Transport
for NSW

TfNSW Reference: SYD21/00574/04

DPIE Reference: SSD-18204994

**EXHIBITION OF EIS - EXHIBITION OF EIS - SNACK BRANDS MANUFACTURING
FACILITY - 14 & 2 DISTRIBUTION DRIVE, ORCHARD HILLS**

Notes:

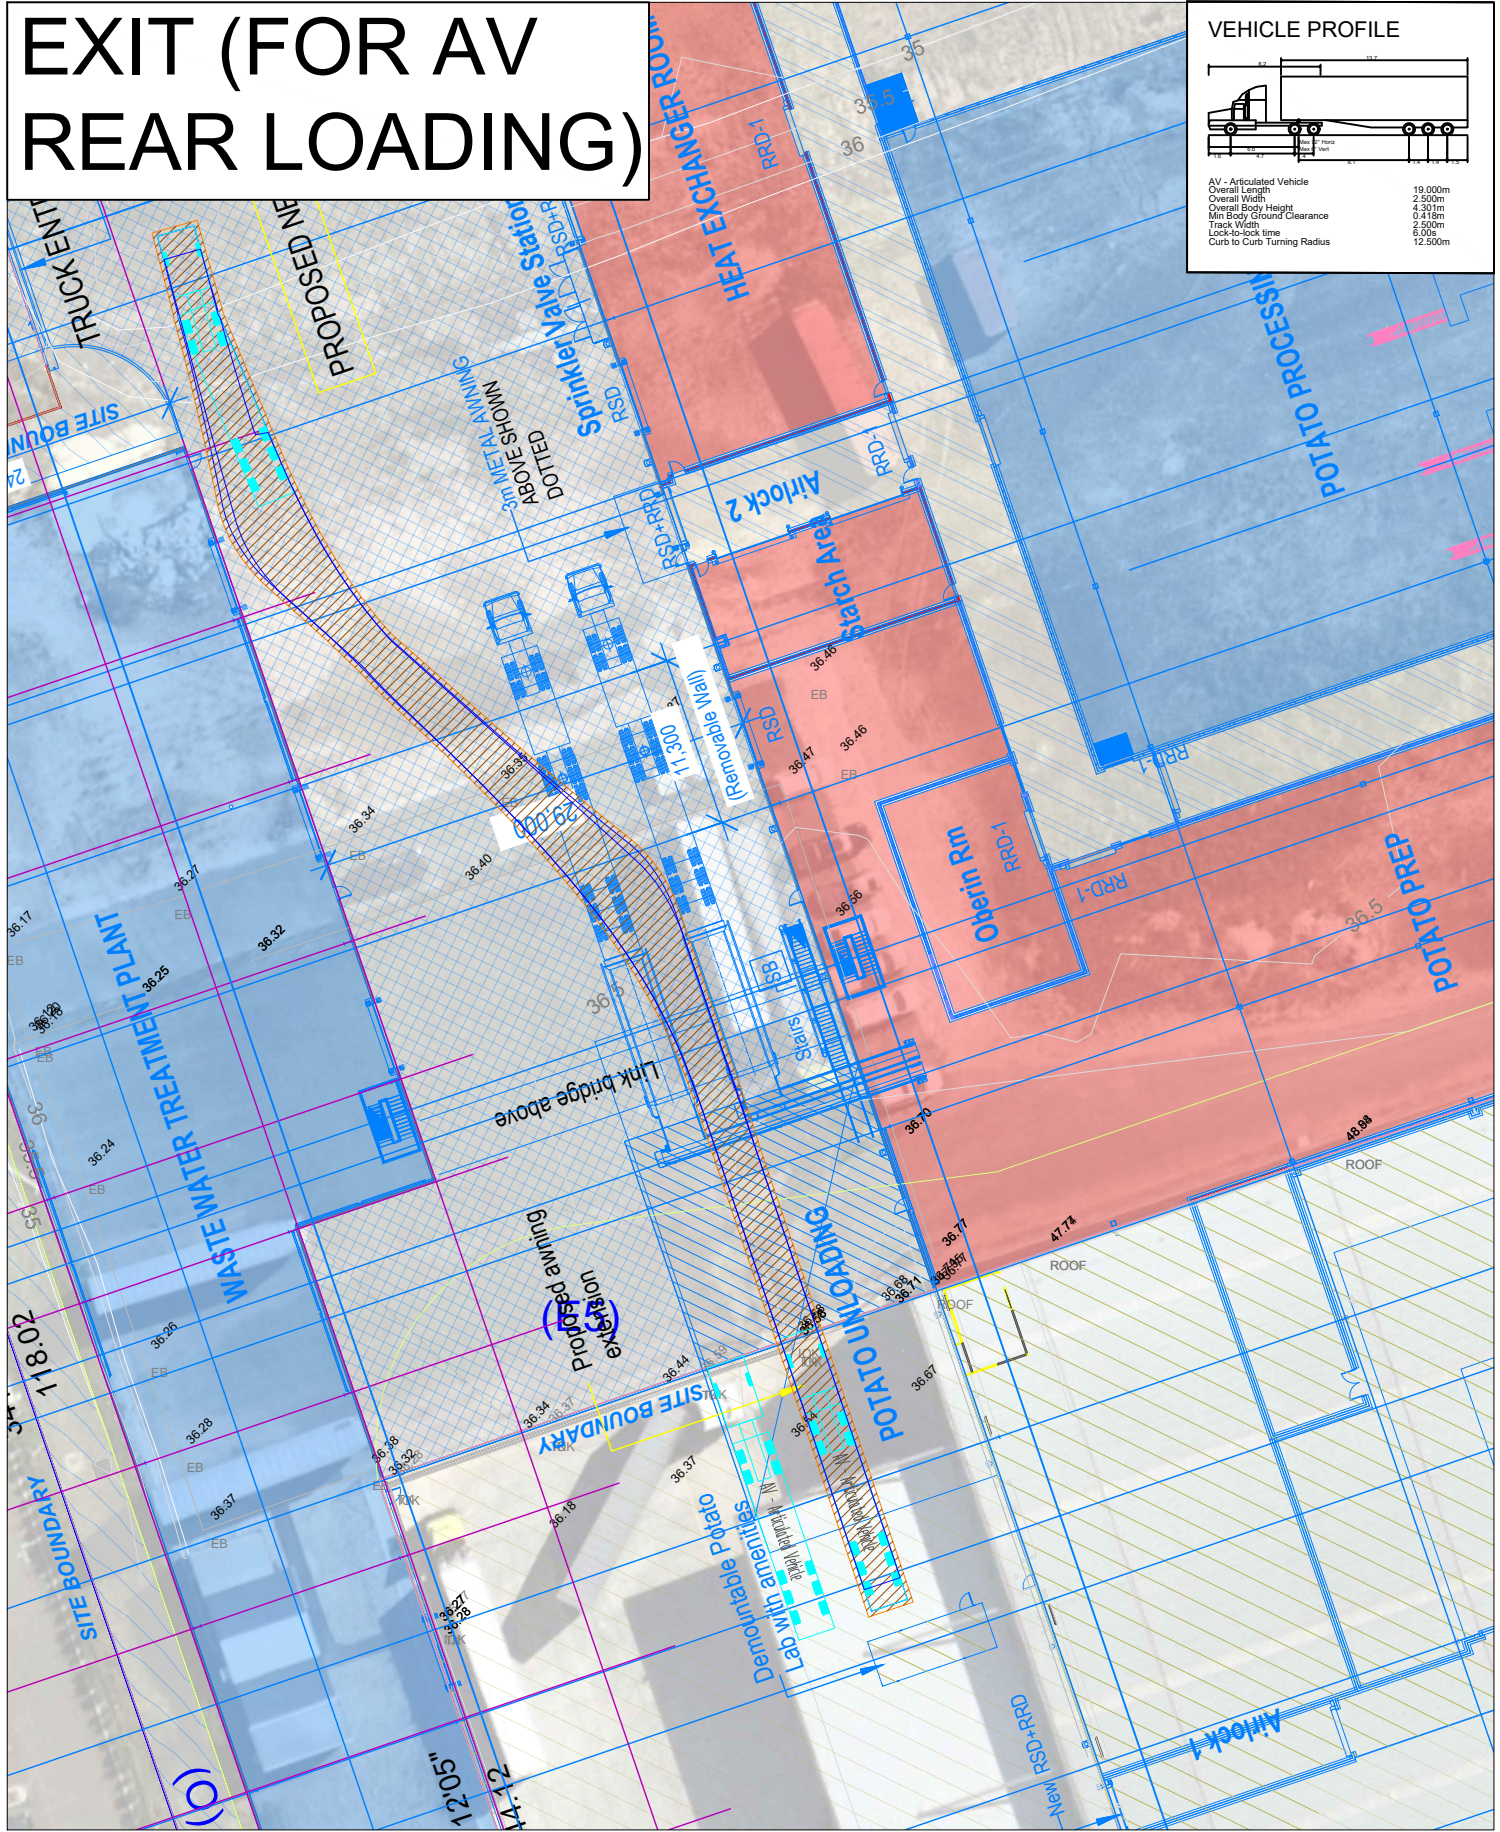
The TA has acknowledged two RSDs where B-doubles will be need to be reversed to unload from the rear. As the rear trailer is in the way, the front trailer (or A-trailer) of a B-double is typically unloaded by de-coupling the trailers, or jack-knifing the combination.

The TA needs to clarify whether a de-coupling area is required so that both the 'A' and 'B' trailers can be unloaded from the rear for the two RSDs which require B-double reverse movements.
